From: Contact Centre (CRM) <contact@ribblevalley.gov.uk>
Sent: 11 August 2024 19:56
To: Planning
Subject: Planning Application Comments - 3/2022/1039 FS-Case-637832954

Planning Application Reference No.: 3/2022/1039

Address of Development: Land adjacent to 115 Kemple View

2 PROPOSED NORTH-EAST (BOUNDARY TO 115 KEMPLE VIEW)
1 : 100

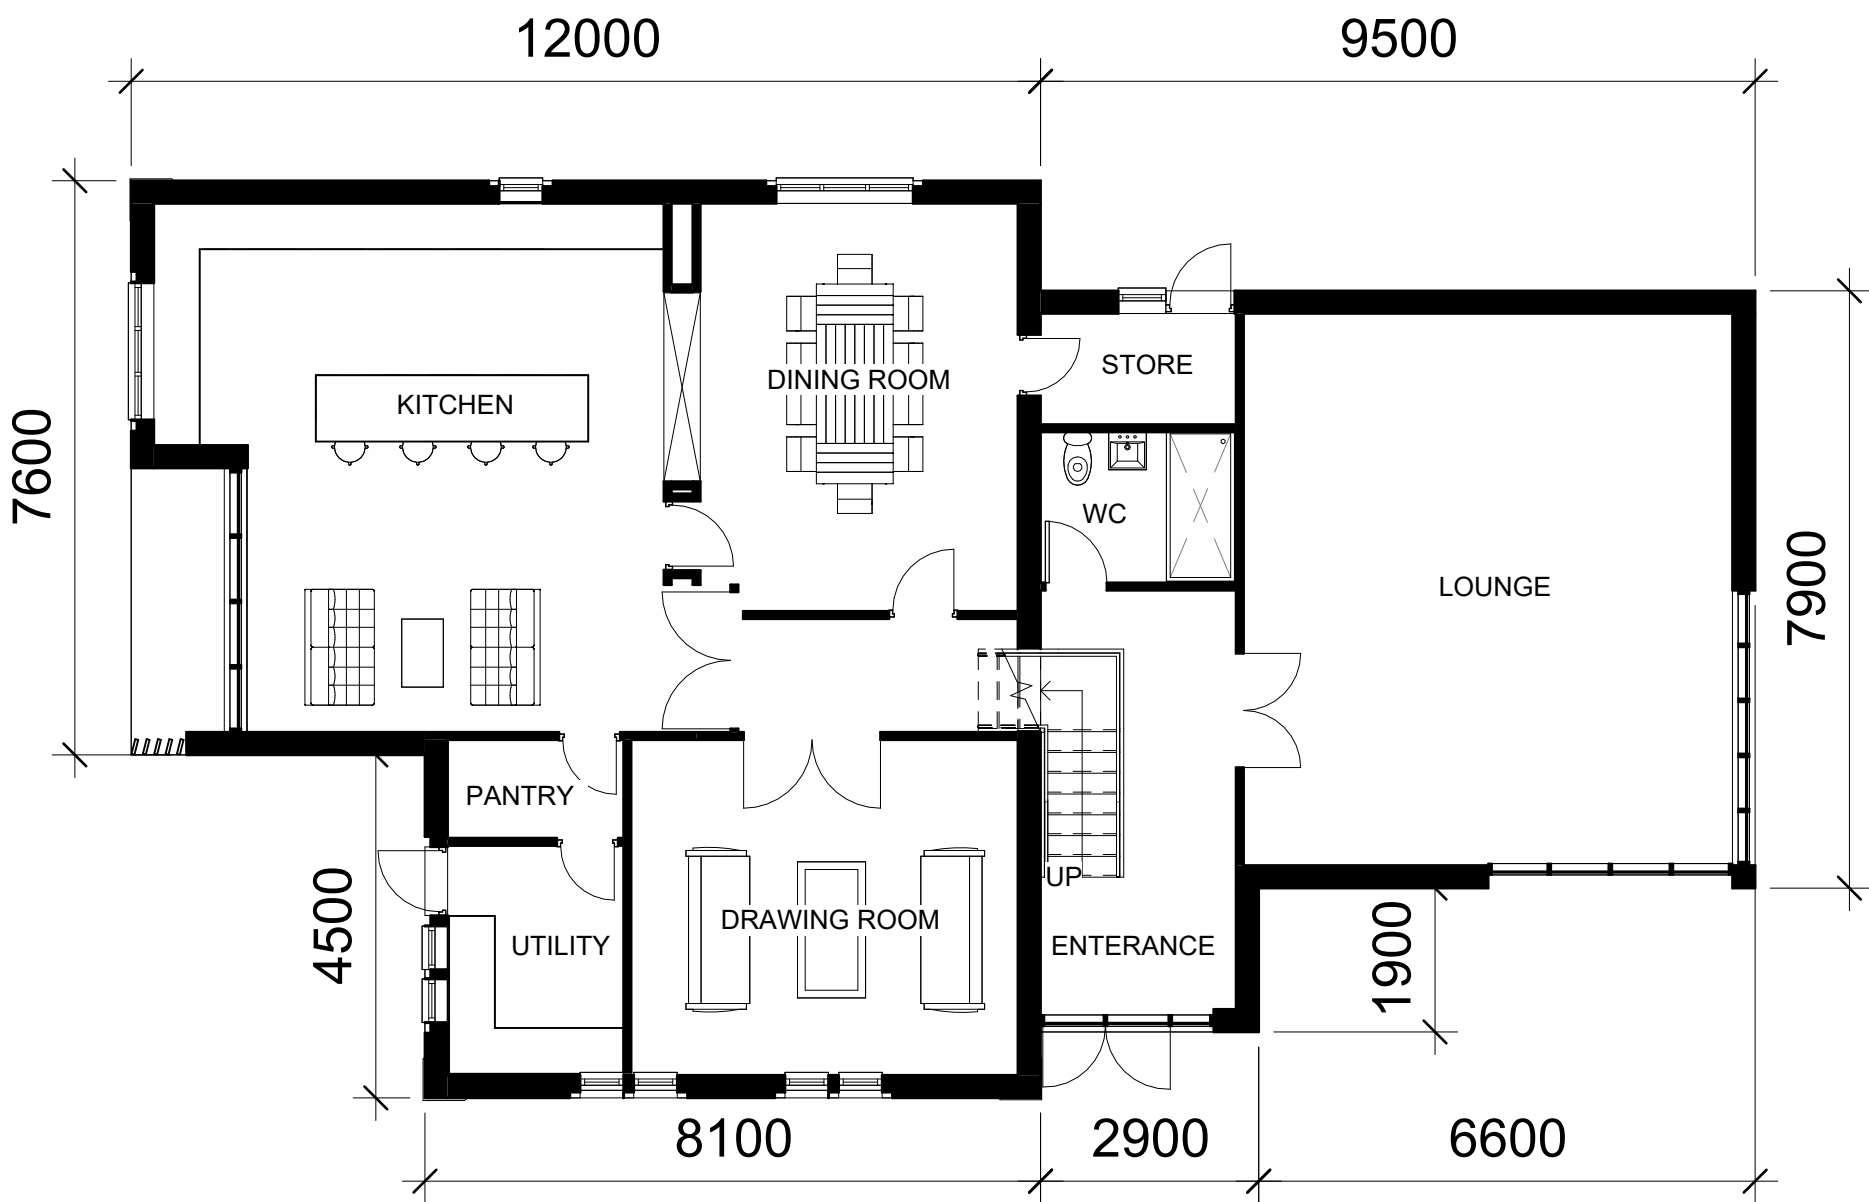
My concerns are firstly we would be [REDACTED], secondly the drains were an issue when we [REDACTED] and third why they are proposing a balcony which looks into all the houses below. Finally what type of residential residence is this?

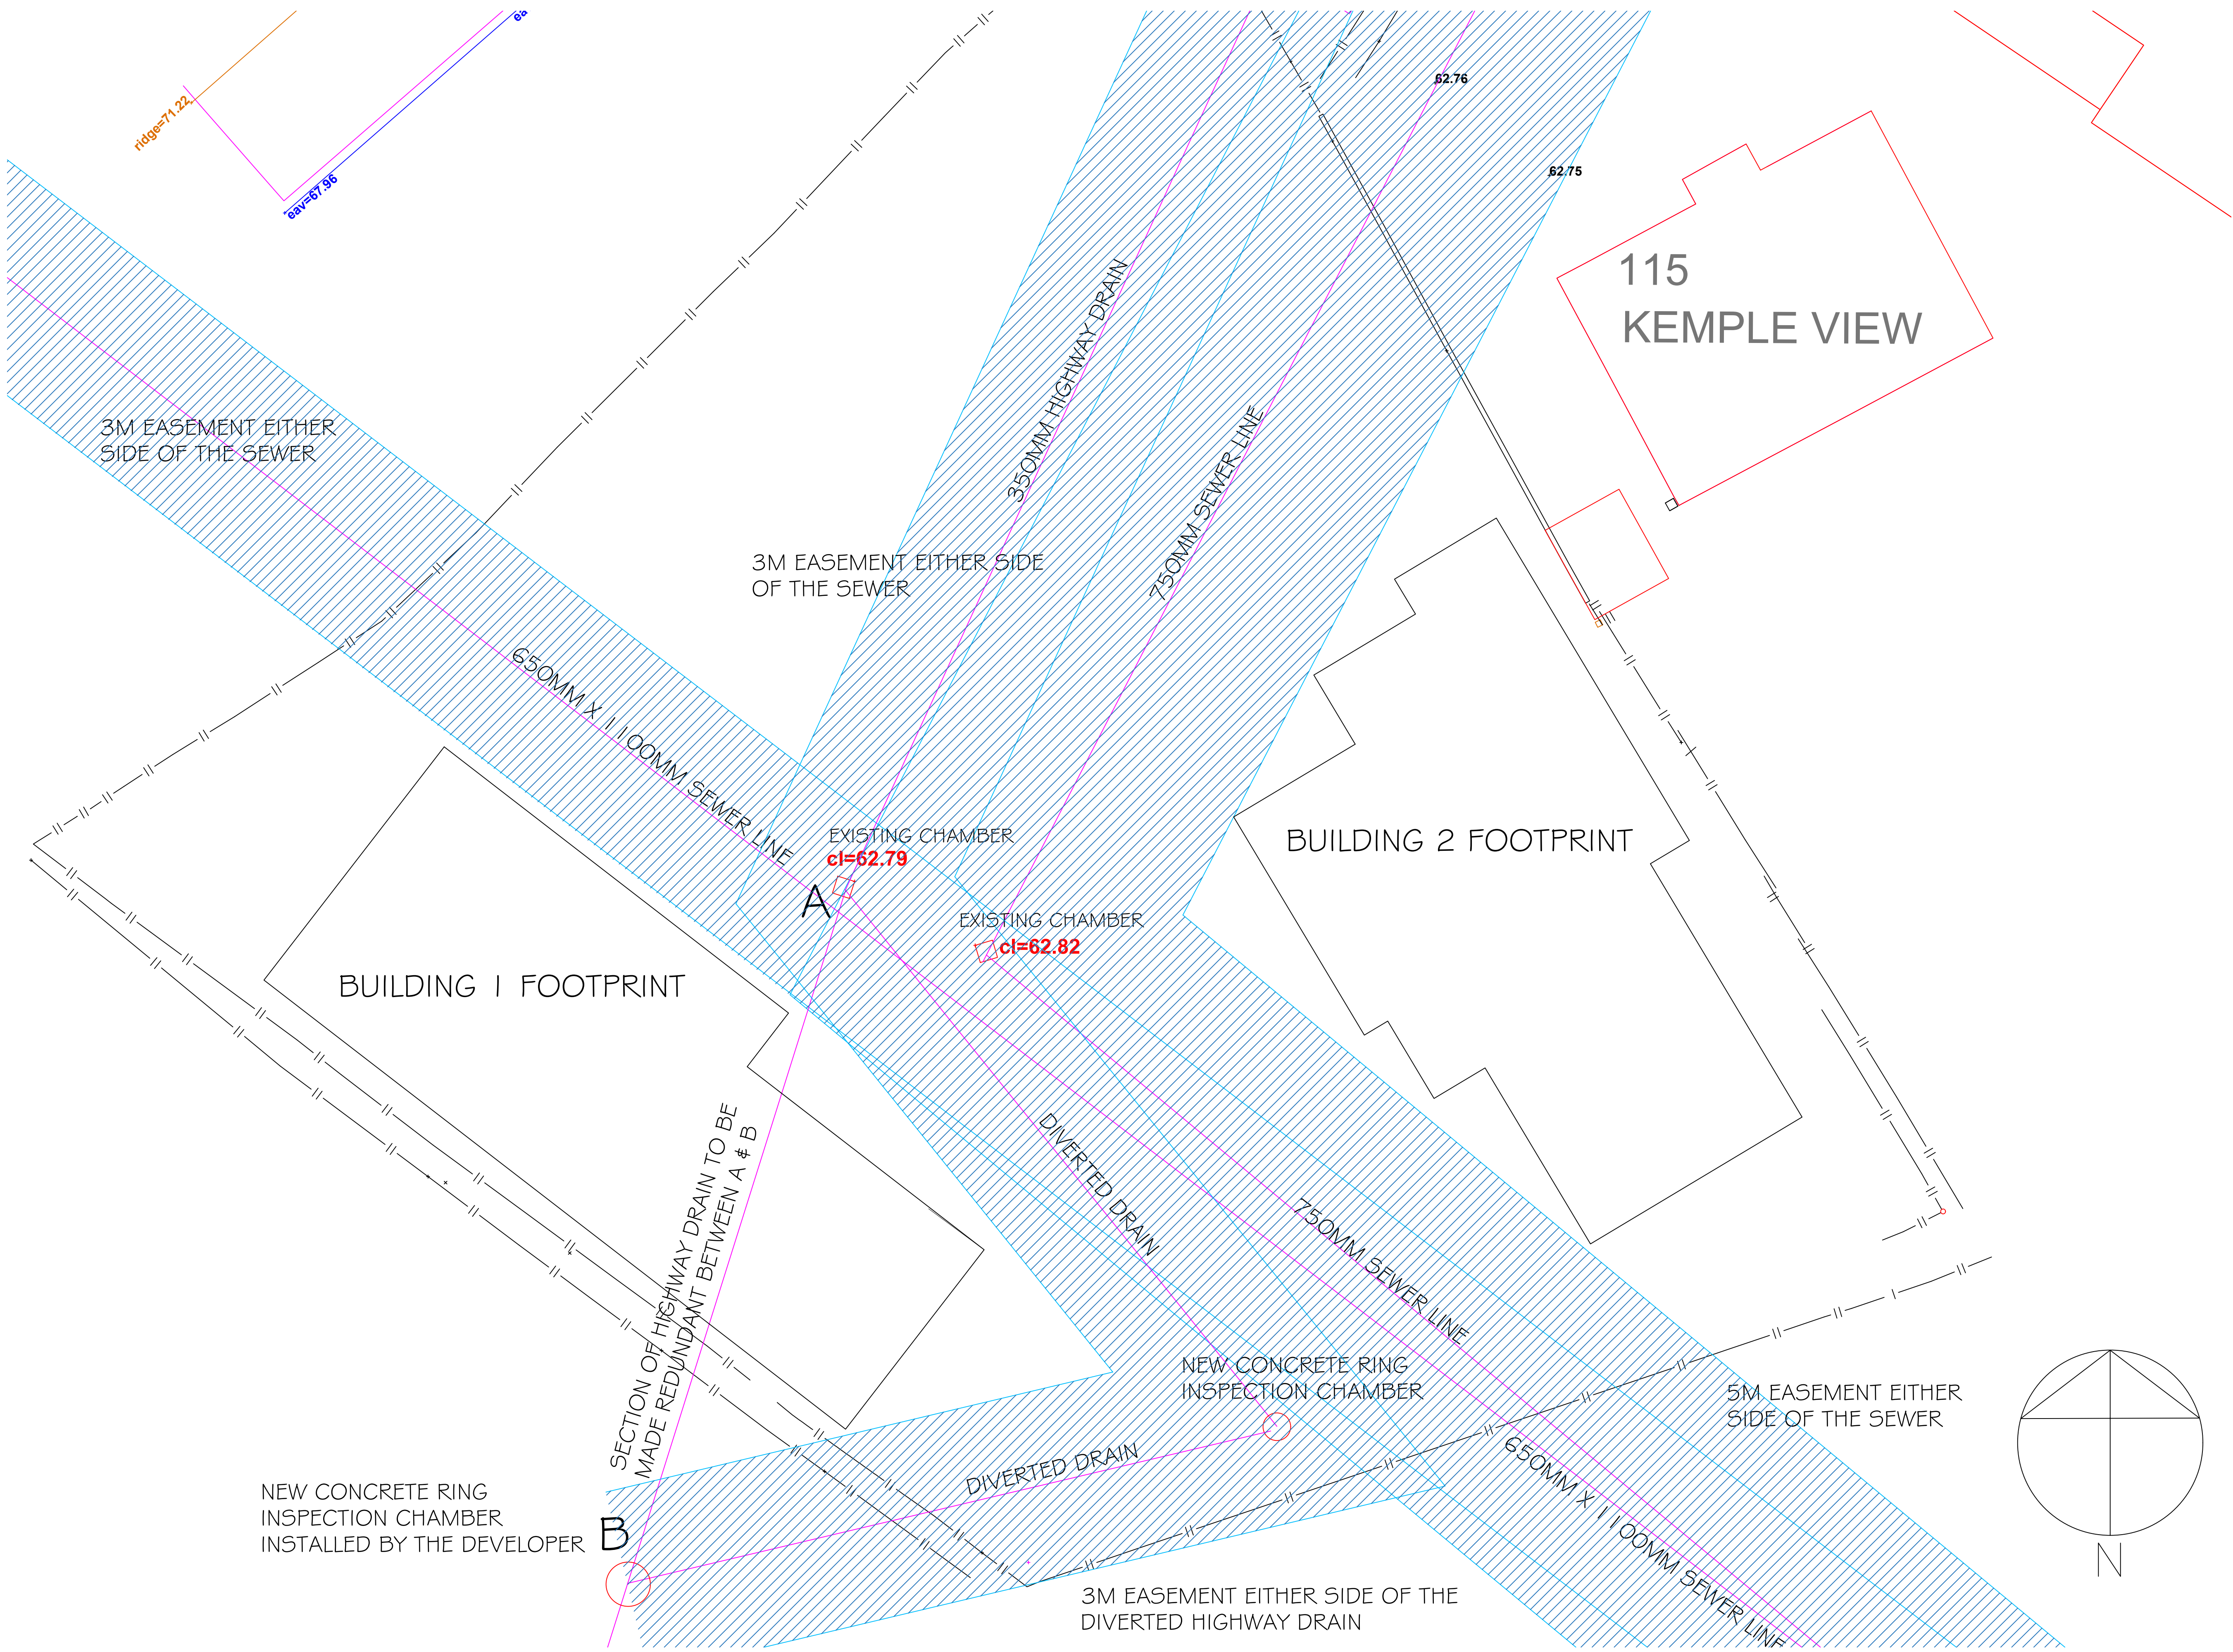
Comments: There is no mention of the water pipelines and the stop tap which services the Stables Building. The Stop Tap and pipes [REDACTED]
[REDACTED] and is connected to the water pipes feeding the Stables Building. [REDACTED]. I note that UU had informed the owner Mr Khan that he should investigate where any water pipes and drains are etc. [REDACTED]
[REDACTED]
